Planning Inspectorate

Our Ref: EN010162

Application by Elements Green Trent Limited for an order granting development consent for the Great North Road Solar and Biodiversity Park

Advice following issue of decision to accept the application for examination

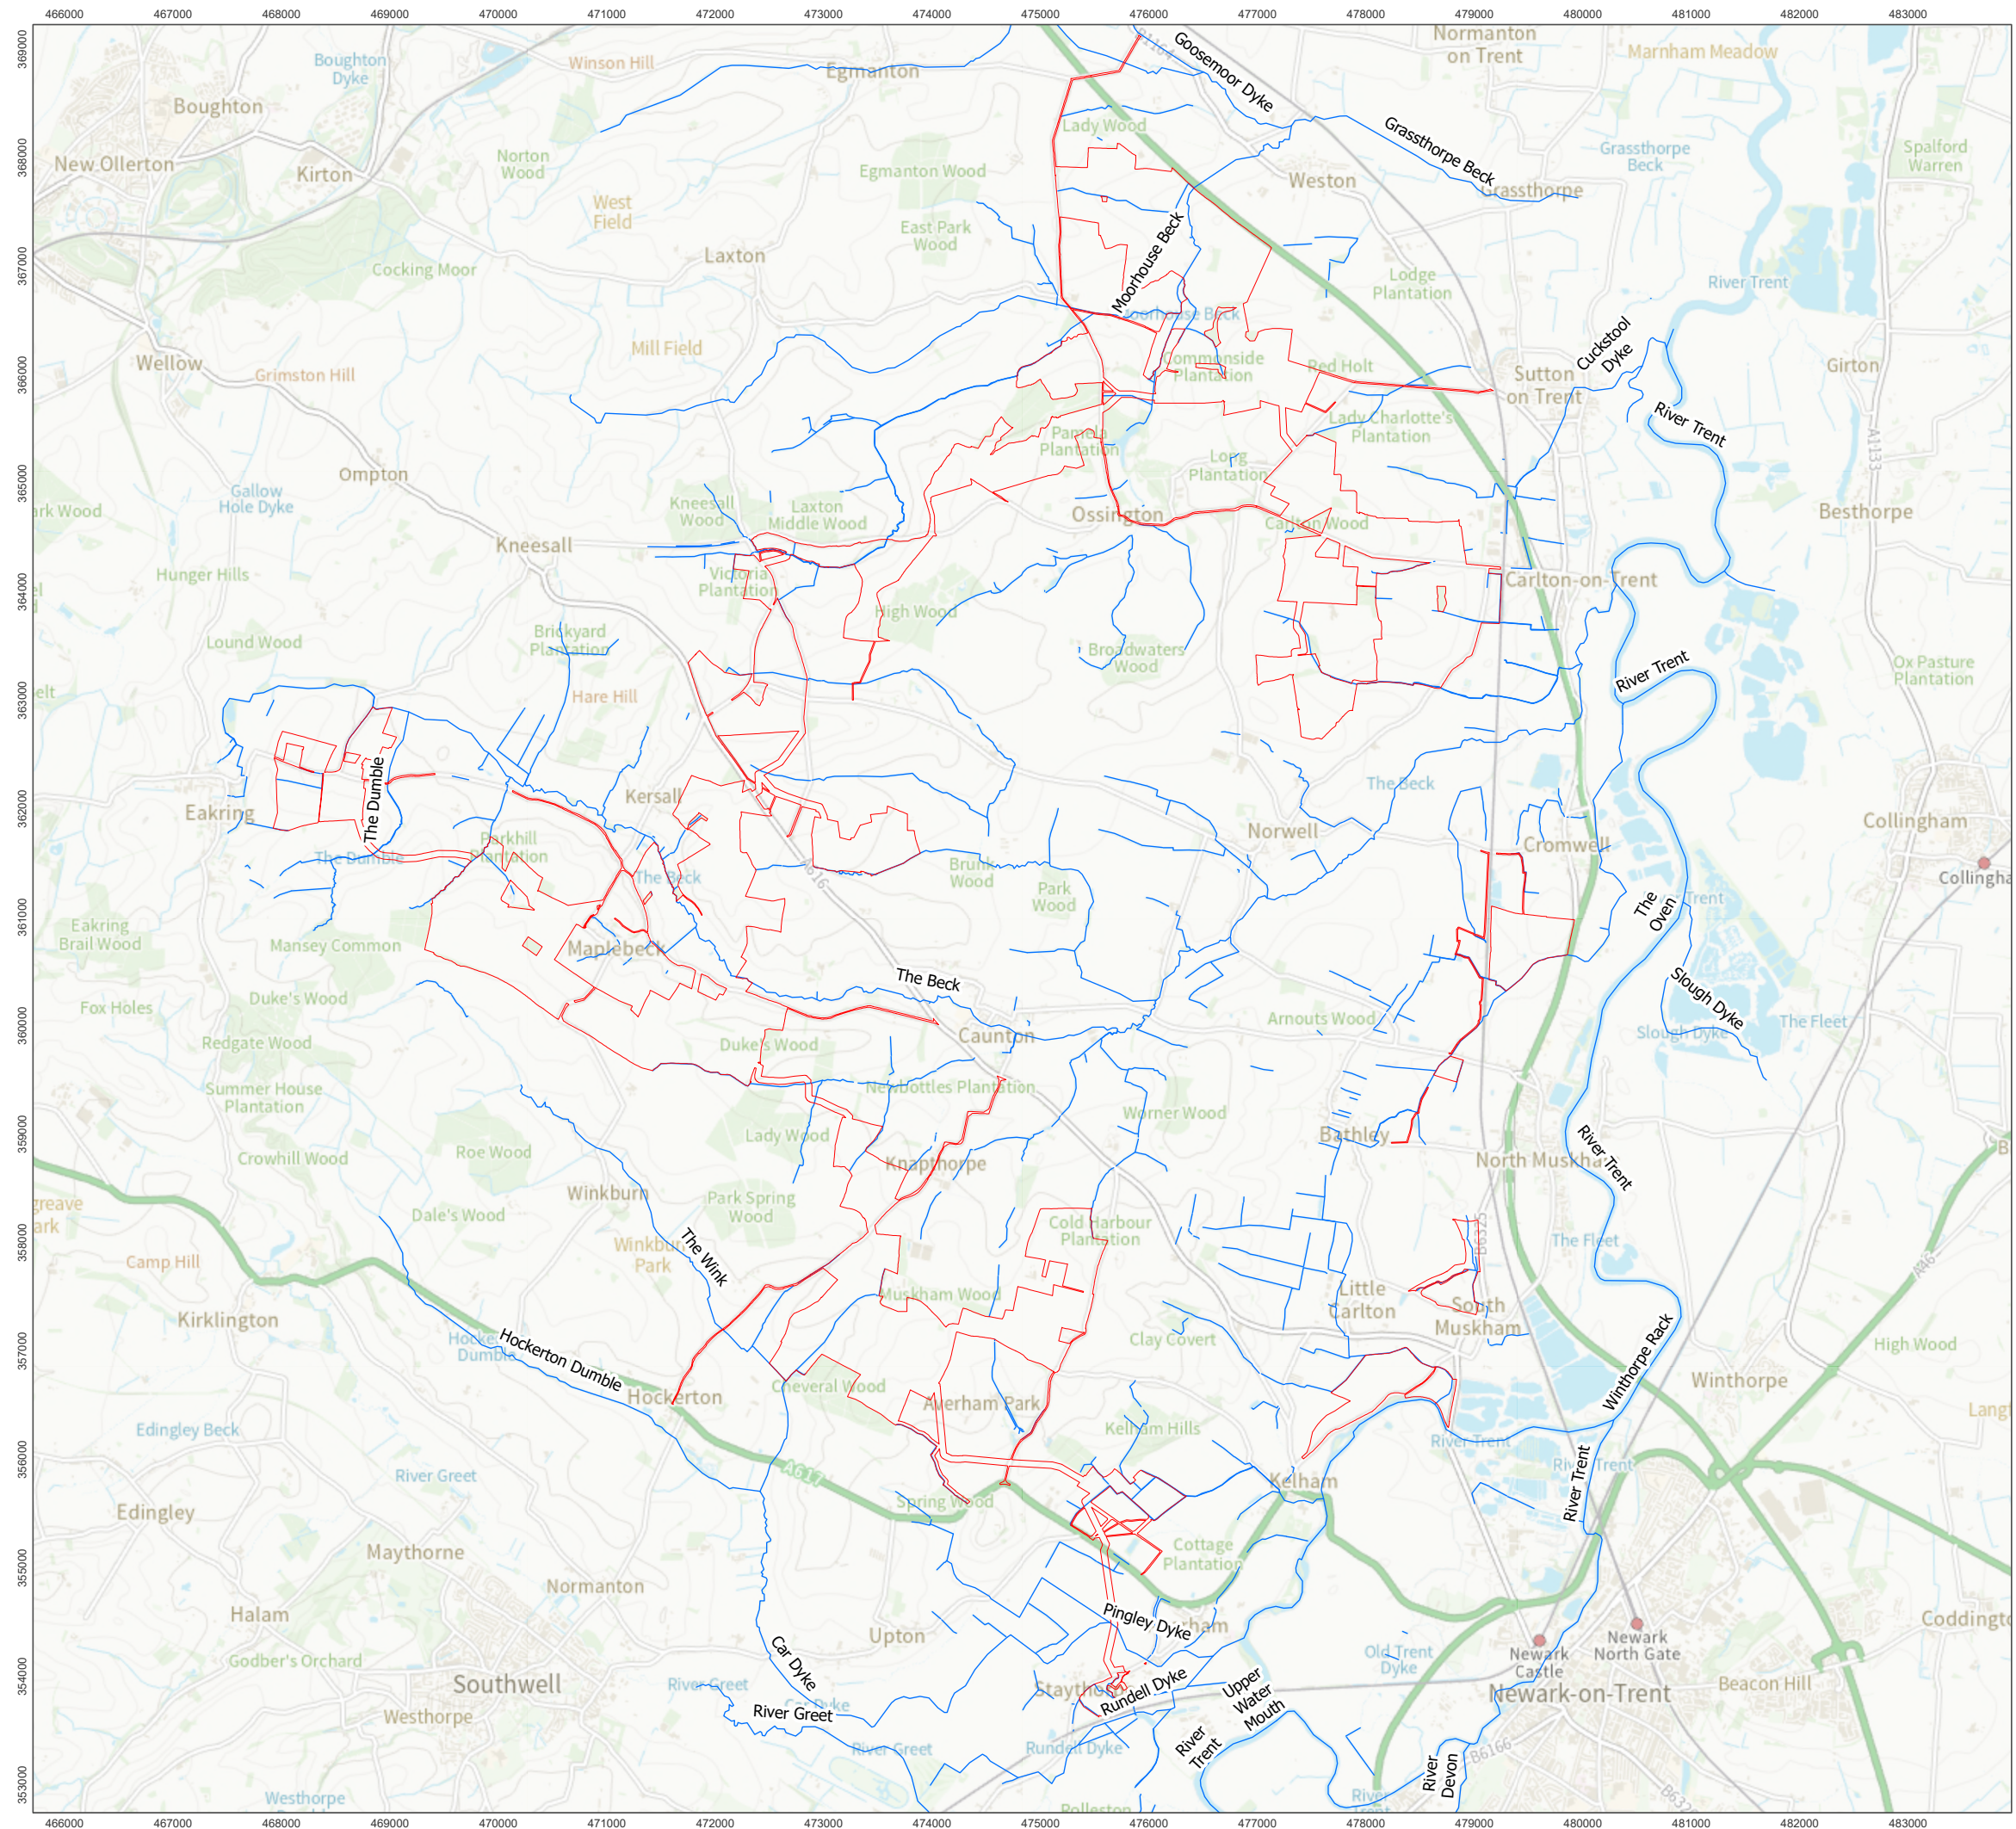
Water Bodies in a River Basin Management Plan (Doc 2.6), Environmental Statement figure 9.4 (Doc 6.3.9.4), ES figure 9.6 (Doc 6.3.9.6), Figures within the Flood Risk Assessment (Doc 6.4.9.1) and Water Framework Directive Assessment (Doc 6.4.9.2)

The applicant is advised to review these figures for clarity and consistency. The figures present varying levels of detail, geographic extent and sub sections/ catchments, waterbody naming and waterbody routes. The Inspectorate advises that the figures should show a consistent presentation of data. The figures should also show, where relevant, the extent of main rivers and ordinary watercourses.
